2024/0728

4 Tenters Green, Worsbrough, Barnsley, S70 5JY

Alterations to roof and installation of front dormer extension to dwelling

Recommendation Refuse

FRONT ELEVATION

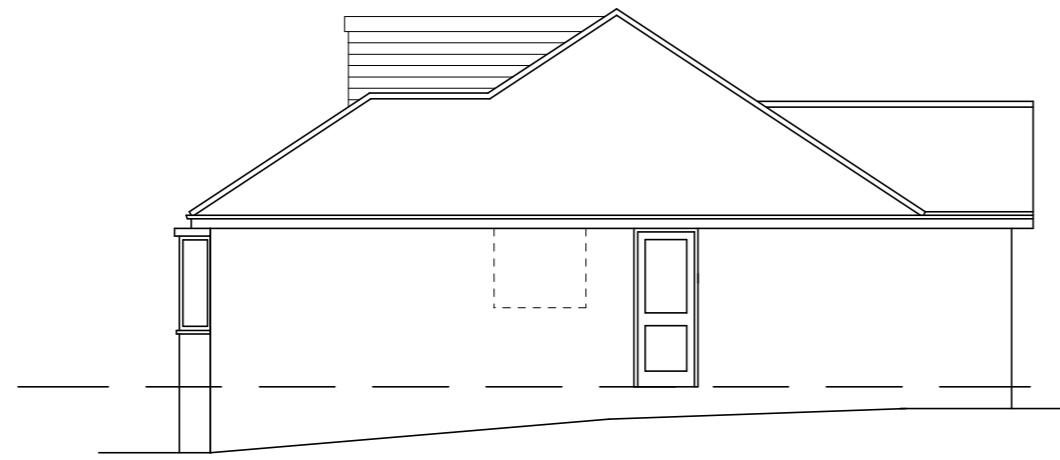
The proposed dormer is considered too large and overly dominant on the site. A change in roof form is required to provide the dormer which changes the existing character of the dwelling. It is acknowledged there has been an attempt to set in the dormer from the west elevation by approximately 0.5 metres and to set the dormer back from the eaves, however there is minimal set down from the ridge. The use of matching materials is acknowledged.

Flat roofed dormers are not considered acceptable as they are considered to be an inferior in terms of construction and aesthetics, especially to principal elections. It is acknowledged the evidence of a flat roofed dormer on the street at 5 Tenters Green, however we do not accept this precedent as this was approved in the year 2000, prior to the current policy and is in contravention to current policy and dormers are not otherwise characteristic of the streetscene. The proposed dormer is also far more dominant on the site dwelling and on the street scene than the dormer at 5 Tenters Green. This will cause additional detrimental impact on the character of the street scene.

In addition, the large dormer is proposed to be located to the to the front elevation of the hipped roof modestly proportioned bungalow and would leave the dwelling appearing unbalanced and asymmetrical within the streetscene, with the extension appearing overly dominant.

SIDE ELEVATION

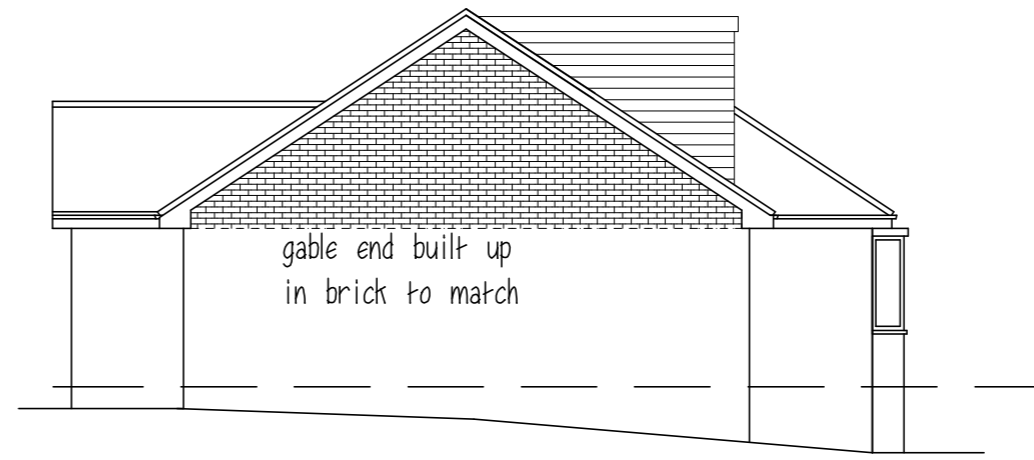
In order to incorporate the dormer size the roof form has been changed on the west side elevation from a hipped roof to a gable roof form. This has an increase in roof volume of approximately 12.3 cubic metres.

The proposed principal elevation dormer would cause some increased overbearing levels to 2 Tenters Green. The change in roof form to gable will reduce the levels of outlook from the principal elevation of 2 Tenters Green increasing this overbearing impact. The addition of the roof dormer would increase this impact. Some increased overshadowing will be caused; however, it is acknowledged this would be mainly restricted to the mornings. No increased overlooking levels will be caused as the proposal would provide no more overlooking impact than the existing principal elevation glazing.
